APPLICATION BY NATIONAL GRID ELECTRICITY TRANSMISSION

**FOR AN ORDER GRANTING DEVELOPMENT
CONSENT FOR THE SEA LINK PROJECT**

(REF: EN020026)

**DEADLINE 3: PORT OF LONDON
AUTHORITY'S COMMENTS ON
SUBMISSIONS RECEIVED AT DEADLINE 2**

Plate 2.1 Stakeholder areas of interest with regard to under-keel clearance

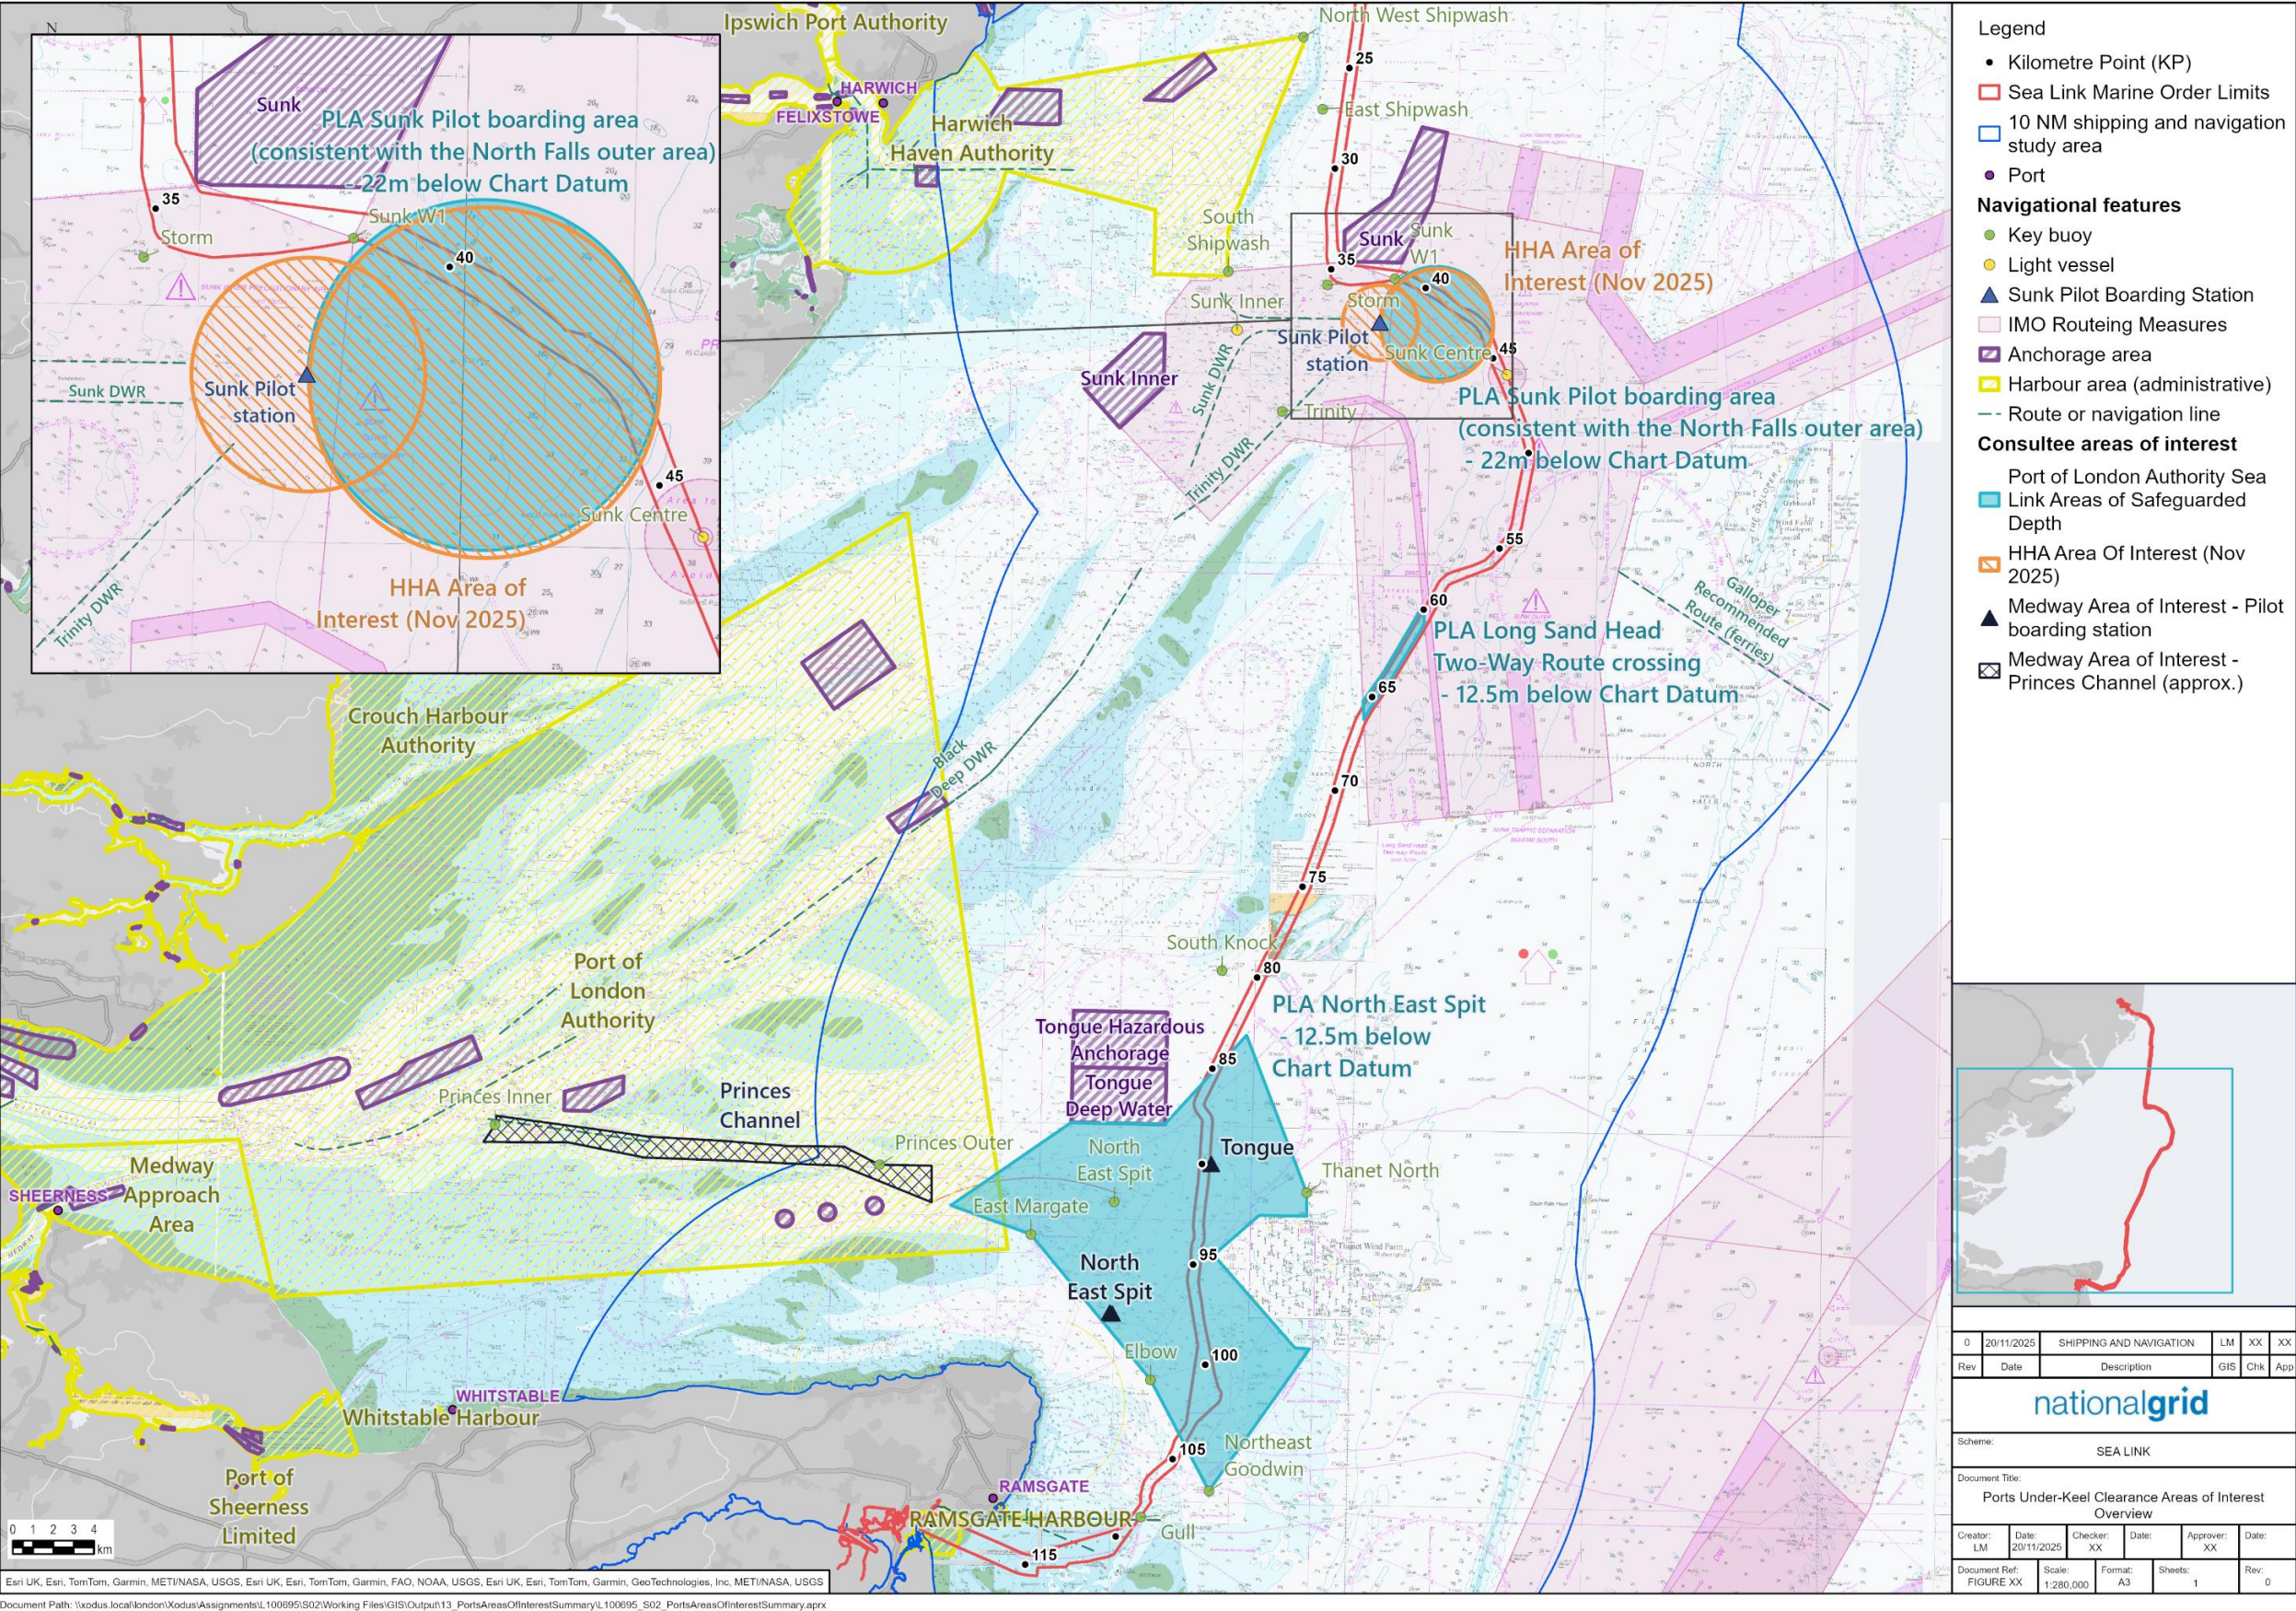
- 2.3 The Applicant asks for clarification on the PLA's reference to the absence of a certified plan and design requirement. The PLA would draw the Applicant's attention to the recent decision on Five Estuaries Wind Farm [PINS Reference: EN010115] which contains a Certified Deep Water Route Cable Installation Area (Future Dredging Depths) Plan [REP6-055] and the Development Consent Order (**DCO**) as made by the Secretary of State. The DCO contains within the Schedule 2 Requirements, offshore design parameters, including at Part 1 (3) a requirement that the cable must be installed and maintained so as not to impede dredging to certain depths in certain locations. The locations being shown on the Certified Plan. A Certified Plan and Requirement is also proposed for the North Falls Offshore Wind Farm [PINS Reference: EN010119]. The PLA is seeking for the Applicant to take a similar approach with the Sea Link Project so it is clear on the face of the Order what water depths must be protected in what areas, regardless of the existing depths, and ensures that there is the ability to dredge to the

required depths. The PLA set out in Section 11 of its Written Representation suggested wording for the Requirement and highlighted the need for the wording to also ensure that GridLink could be accommodated should it be installed after Sea Link. The PLA suggest the following wording:

"Requirement X

That any part of Work No.6, including any associated development or ancillary works, located within the Areas of Interest must be installed at a level which would not impede the dredging of those parts of the Areas of Interest to the following depths:

- (a) *Labelled "Sunk Pilot Boarding area", to a level of 22 metres below Chart Datum; and*
- (b) *Labelled "Long Sand Head Two-Way Route crossing", to a level of 12.5 metres below Chart Datum; and*
- (c) *Labelled "North East Spit area" to a level of 12.5 metres below Chart Datum;*

and in all cases (a) to (c) makes allowance for an 'over-dredge' tolerance of 0.5 metres in addition to the stated depths attributable to standard dredging methodology.

Requirement Y

When complying with Requirement [X] the installation level of any part of Work No.6, including any associated development or ancillary work, must be at such a level that case (c) will be achieved even after any part of the works is crossed by the cable(s) for the GridLink Interconnector Project within the Areas of Interest."

**Plate 4.1 Overview of the water depths within the Area of Interest and the Sunk wider area. Extract of Figure 10:31 from the Integrated Geophysical and Geotechnical Survey Report (NEXT GEO 2025)**

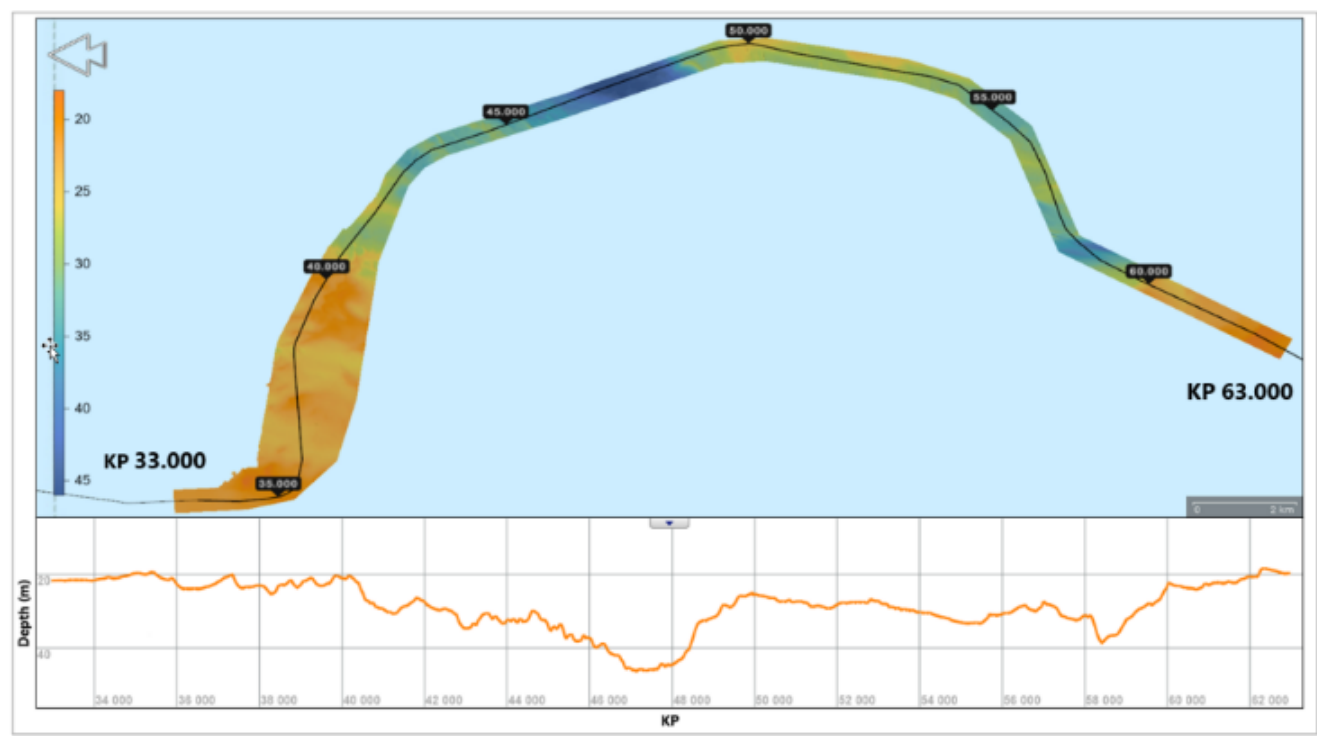
- 2.4 In relation to reference 5.8, further information is given by the Applicant regarding the Target Depth of Lowering (**TDoL**) which the Applicant states will need to safeguard under keel clearance in the areas of interest, which will be secured through DCO requirements and Protective Provisions and supported by management plans such as the OCSIP. The PLA needs to see the DCO requirements, Protective Provisions and management plans in order to have the certainty that the TDoL will safeguard under keel clearance.

**Plate 4.3 Overview of the water depths within the Area of Interest and the Long Sand Head wider area. Extract of Figure 10:45 from the Integrated Geophysical and Geotechnical Survey Report (NEXT GEO 2025)**

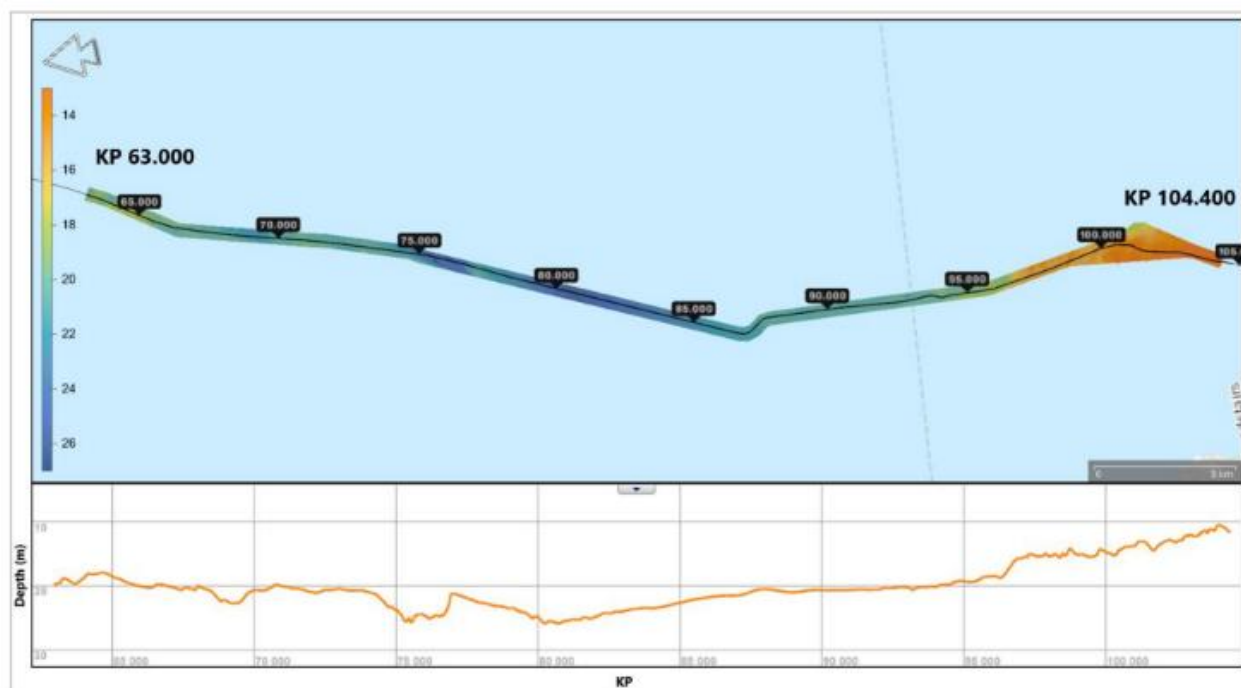
- 2.6 At entry Reference 10.3 the Applicants states – the Applicant's understanding is that the *"Long Sand Head Two-Way Route Crossing Area"* is specifically relating to water depth safeguarding, and not traffic management. The PLA disagrees. The PLA is concerned about traffic management in the Long Sand Head two-way route as well as water depth.
